MODIFICATION REQUEST:

**92, Manning Street, Tuncurry.
7 storey Commercial/retail building Lot 1 DP
301489. MP08_0042 (Mod.2).**

Director-General's
Environmental Assessment Report
Section 75W of the
Environmental Planning and Assessment Act 1979

March 2012

NORTH ELEVATION
SCALE 1:200

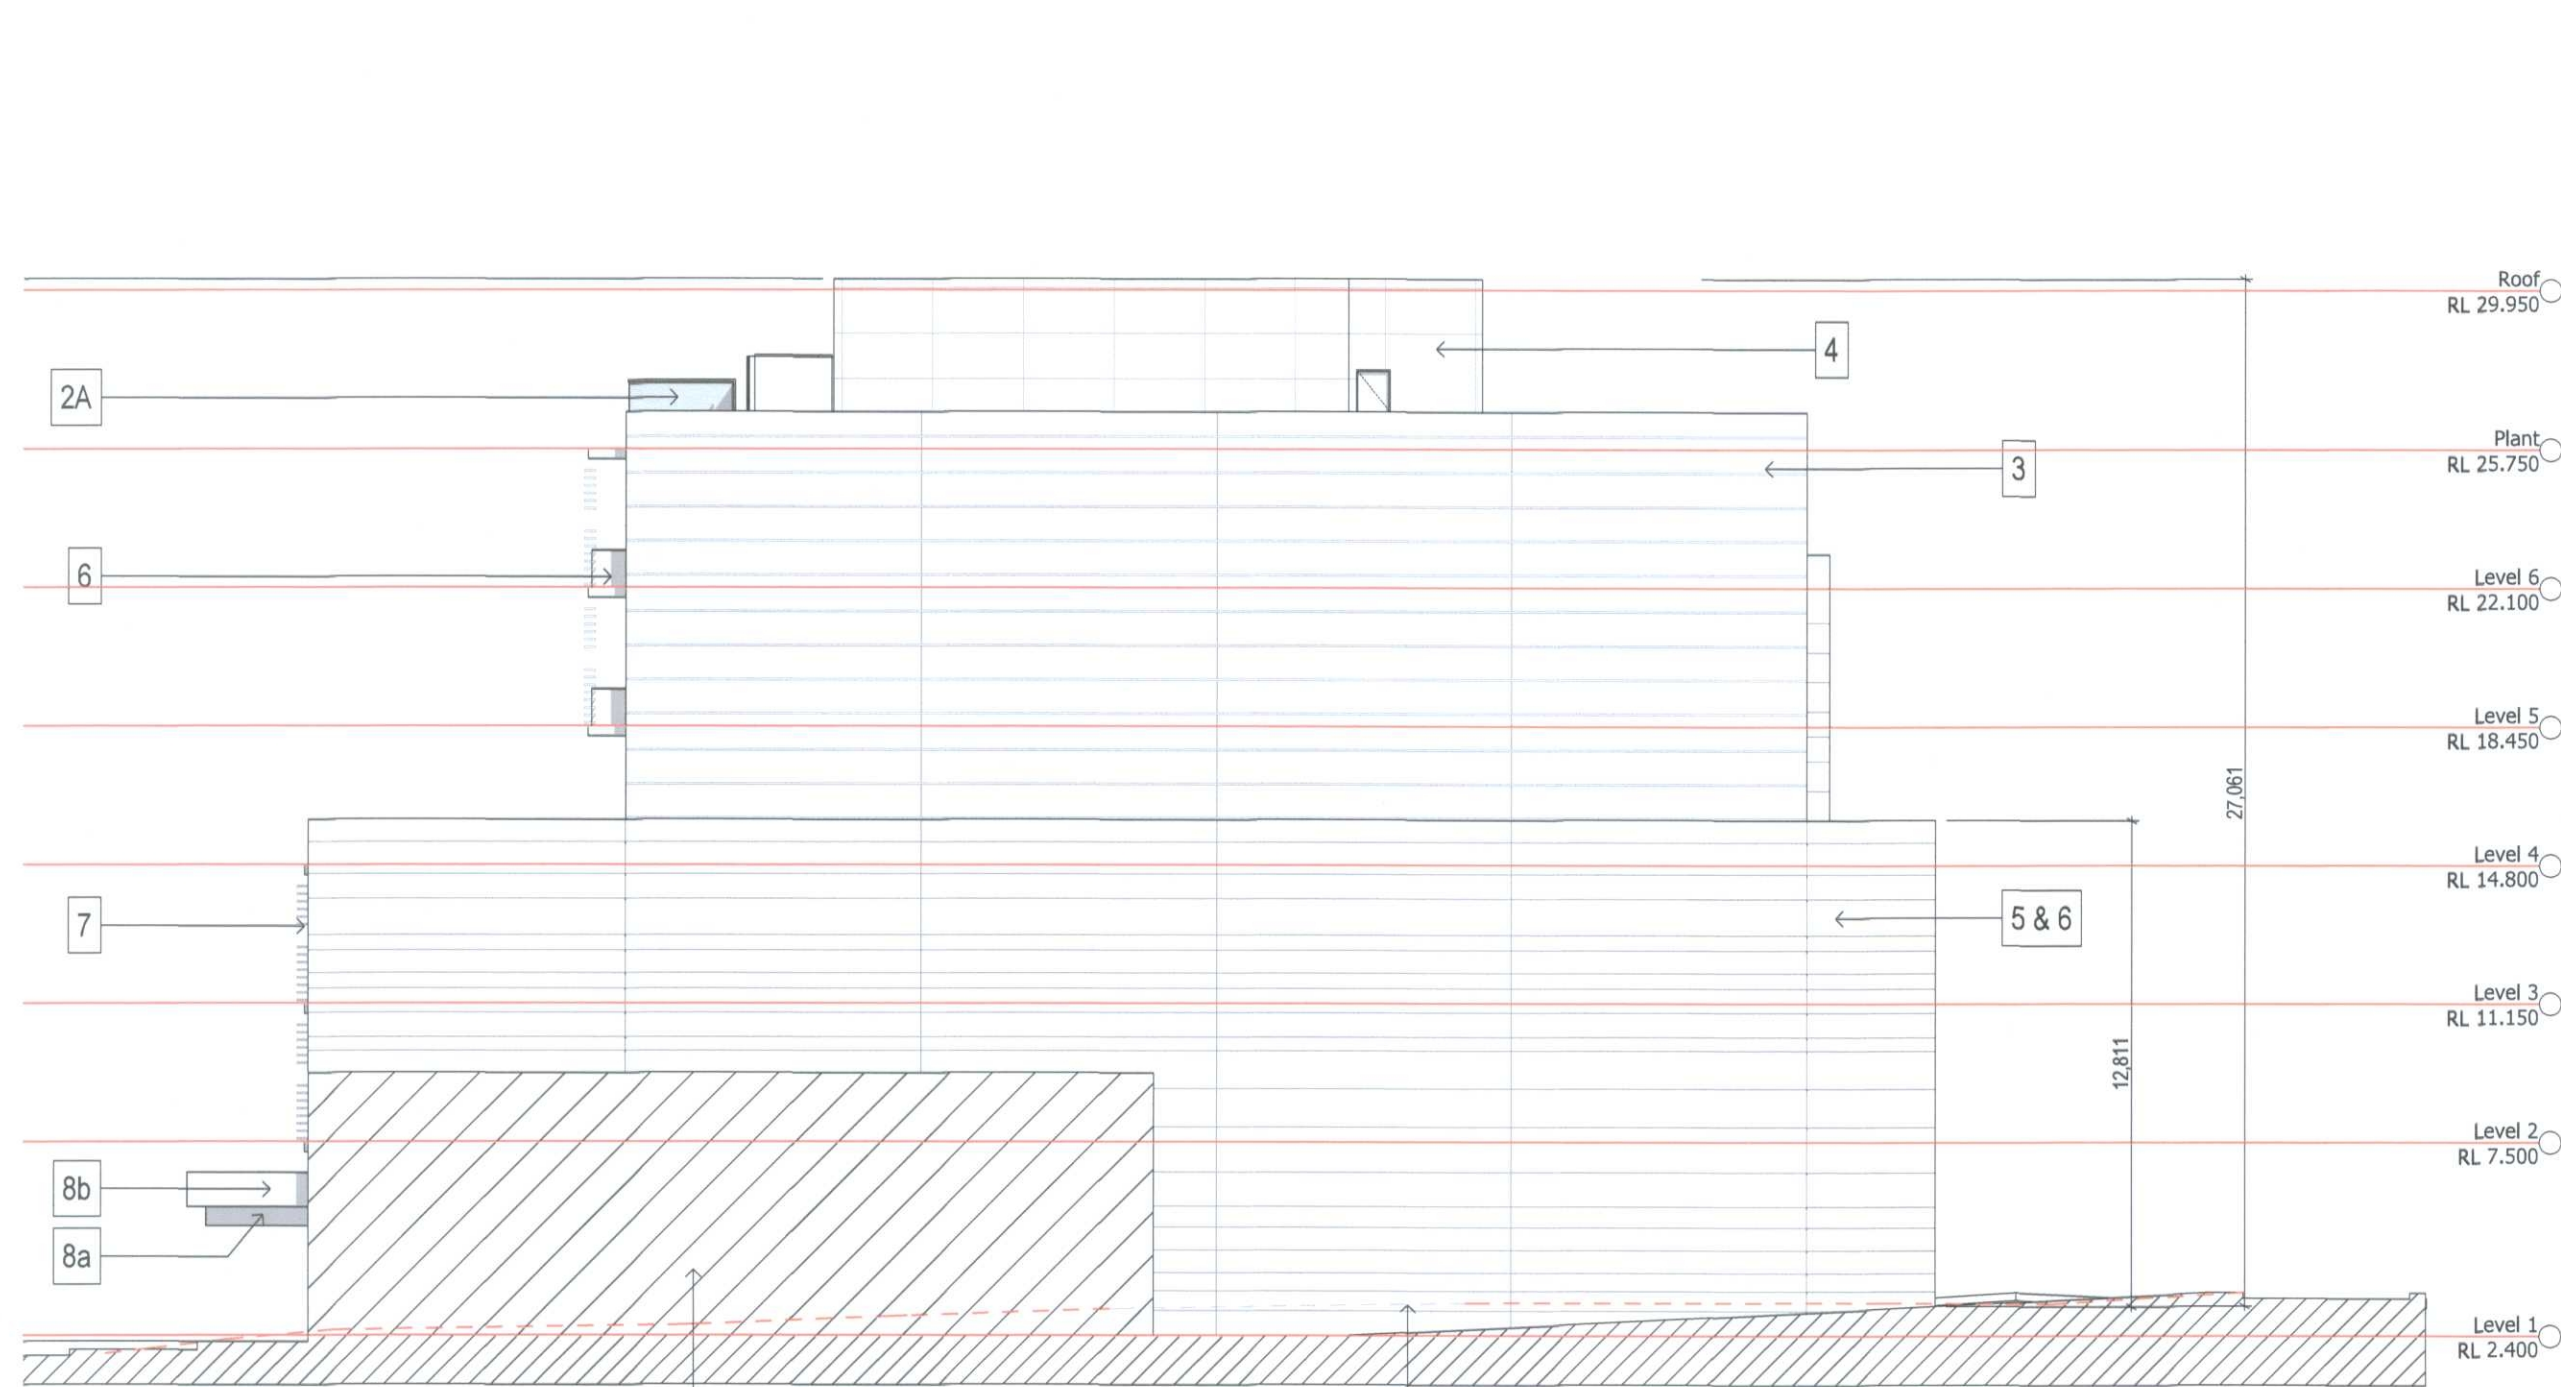
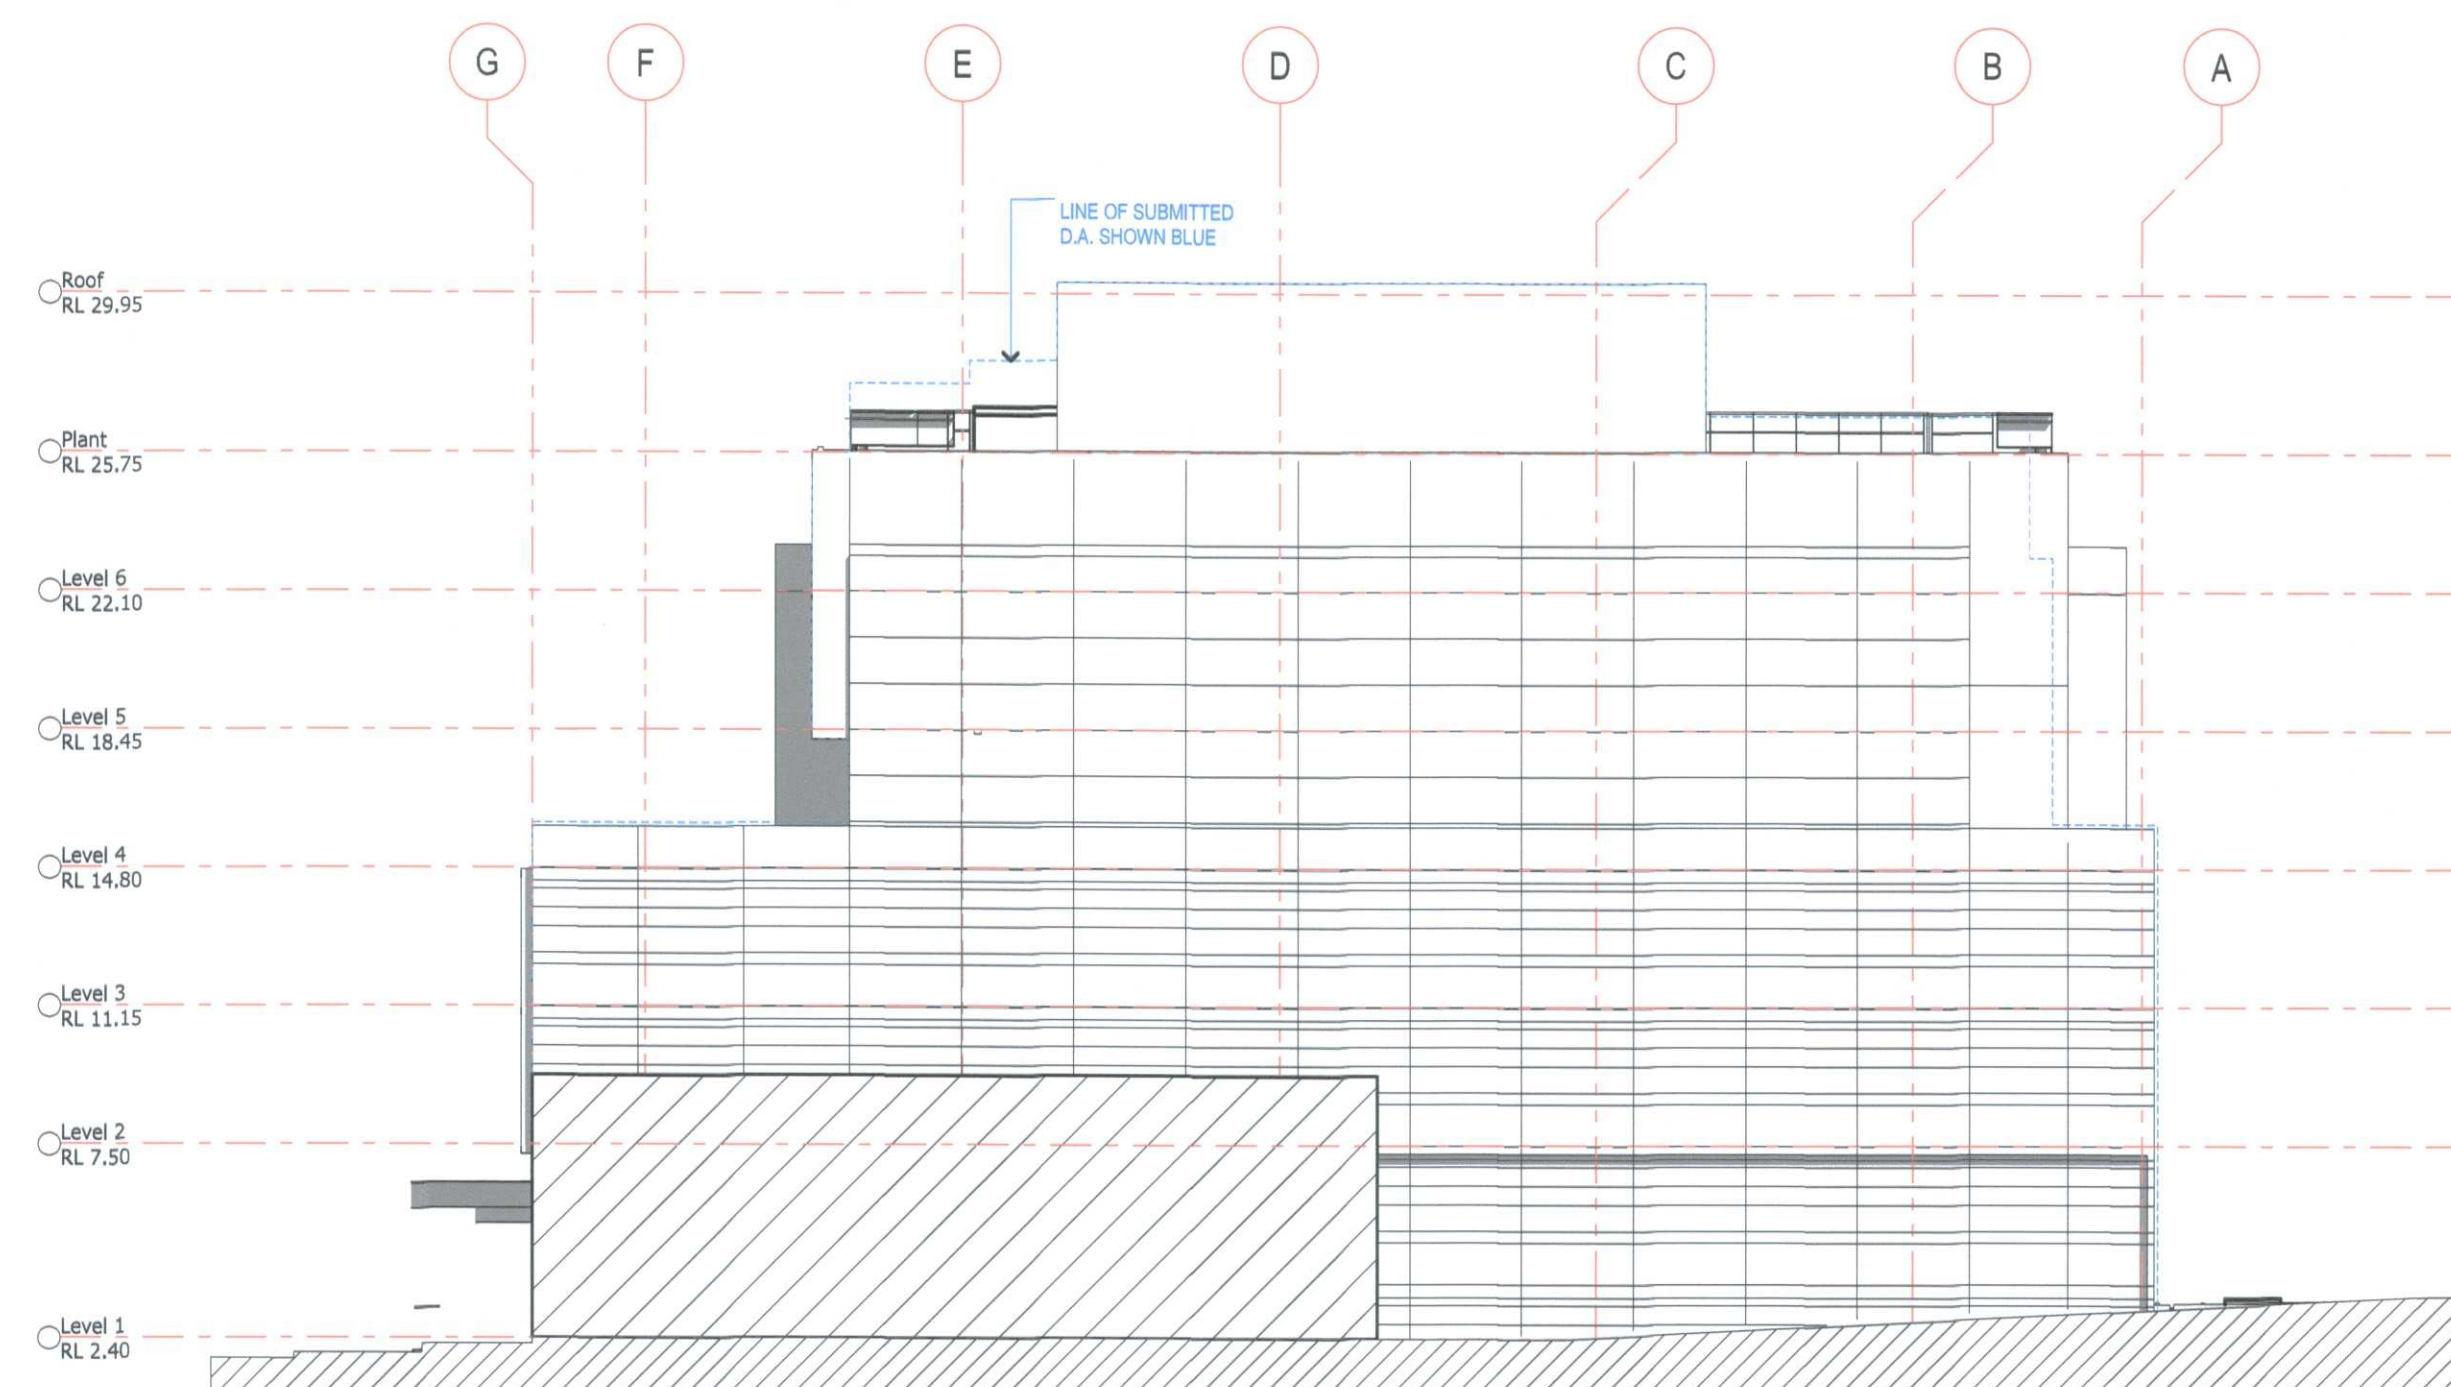
4. Other minor design modifications (item b, c, g, h in Table 1)	<p>These proposed modifications are minor, making little difference in the overall appearance of the building. However, in terms of the overall composition of the building, the Department's Team Leader, Urban Design, advises that the revisions represents an improvement to the original scheme.</p>
